Your ref: 3/2018/0395

Date: 2nd July 2018

Planning Application 3/2018/0395: Resubmission of planning application 3/2017/1021. Demolition of lean-to extension to side, and erection of two-storey extension to side. Susie Cottage, Rimington Lane, Rimington BB7 4DT

Proposed Plans & Elevations

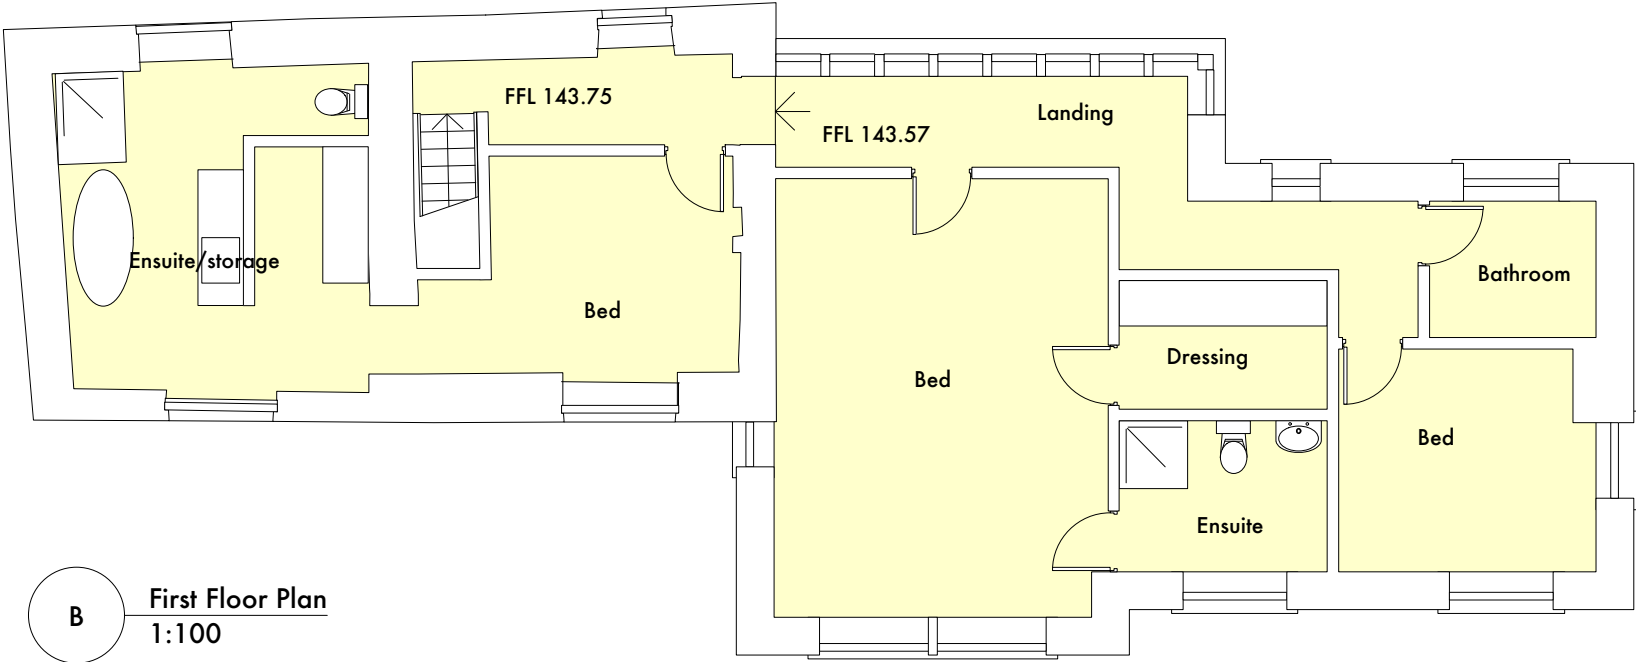
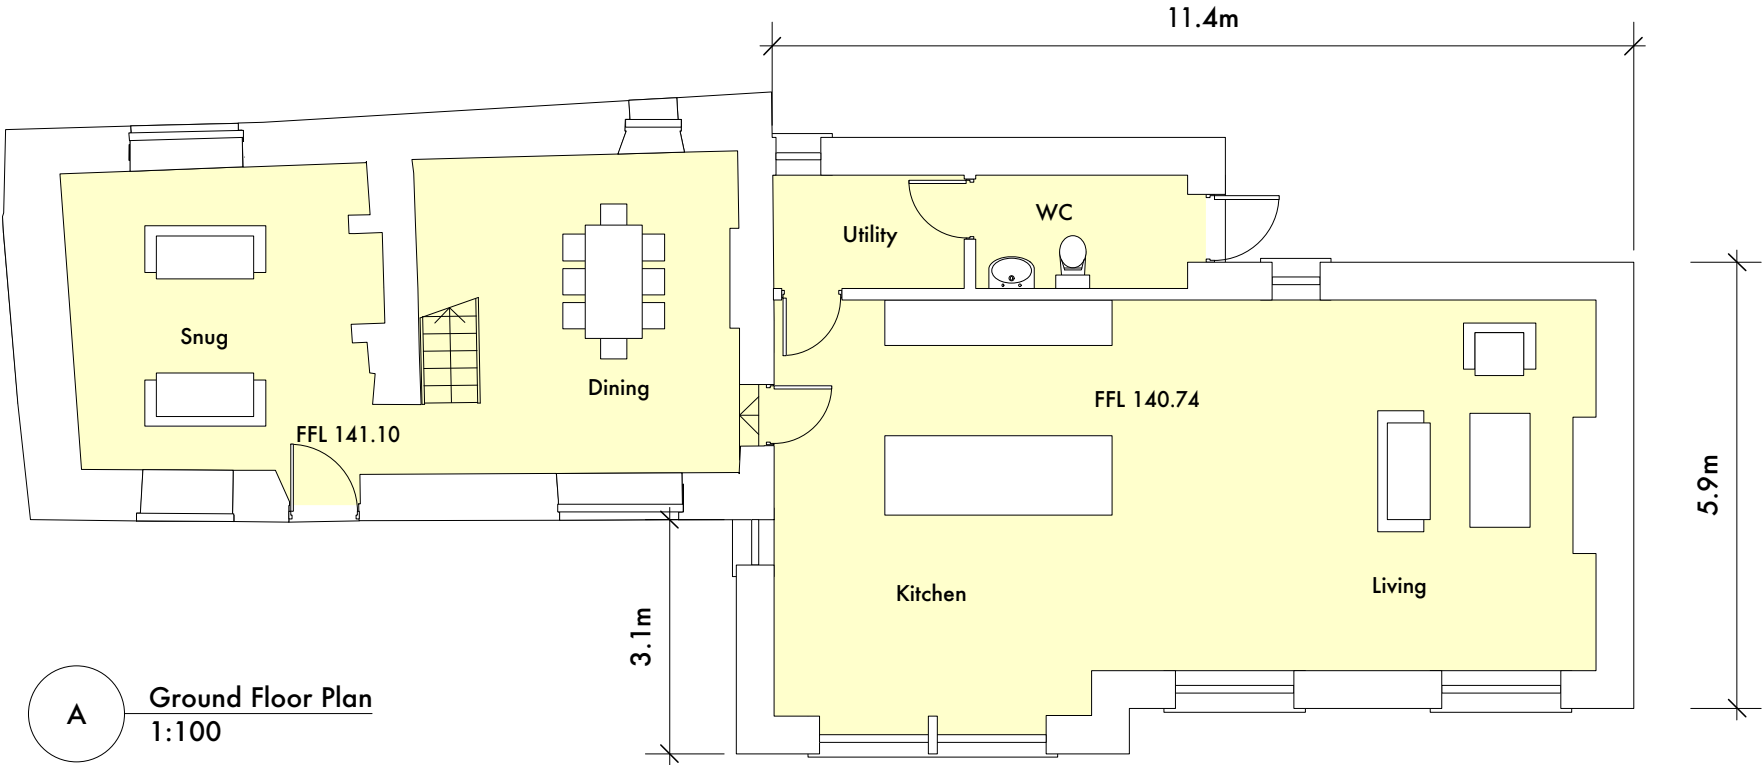
The proposed new development appears to retain most of the extant historic building, a single new opening being proposed through the northeast gable on each floor, that to the ground floor replacing an existing window opening. It is not clear however if the proposals retain the existing roof truss and the existing ceiling beams (although this would seem possible). The proposed repair and 'making good' works are not specified in any detail, and it is not known if the existing brick elements are to be removed and replaced with matching stone and if the remaining render is all to be removed. It is noted that existing windows include a number of wooden sliding sash windows (HS Figures 4 and 5) and proposed windows are noted as 'grey aluminium'. The extent of these direct impacts on the building are thus hard to quantify, and it is not possible to say without further information if it should be considered a 'substantial' or 'less than substantial' impact.

The proposed new extension is a considerable size and from the plans as proposed would appear to be (measured externally and using the dimensions quoted) to be 86.36 sqm per floor, compared to the 55 sqm of the original. The extension is thus 156.66% of the size of the original. If internal measurements are used, the percentage increase is likely to be higher. As such it is certain that the proposals will have a large and significant effect on the setting of the existing building.
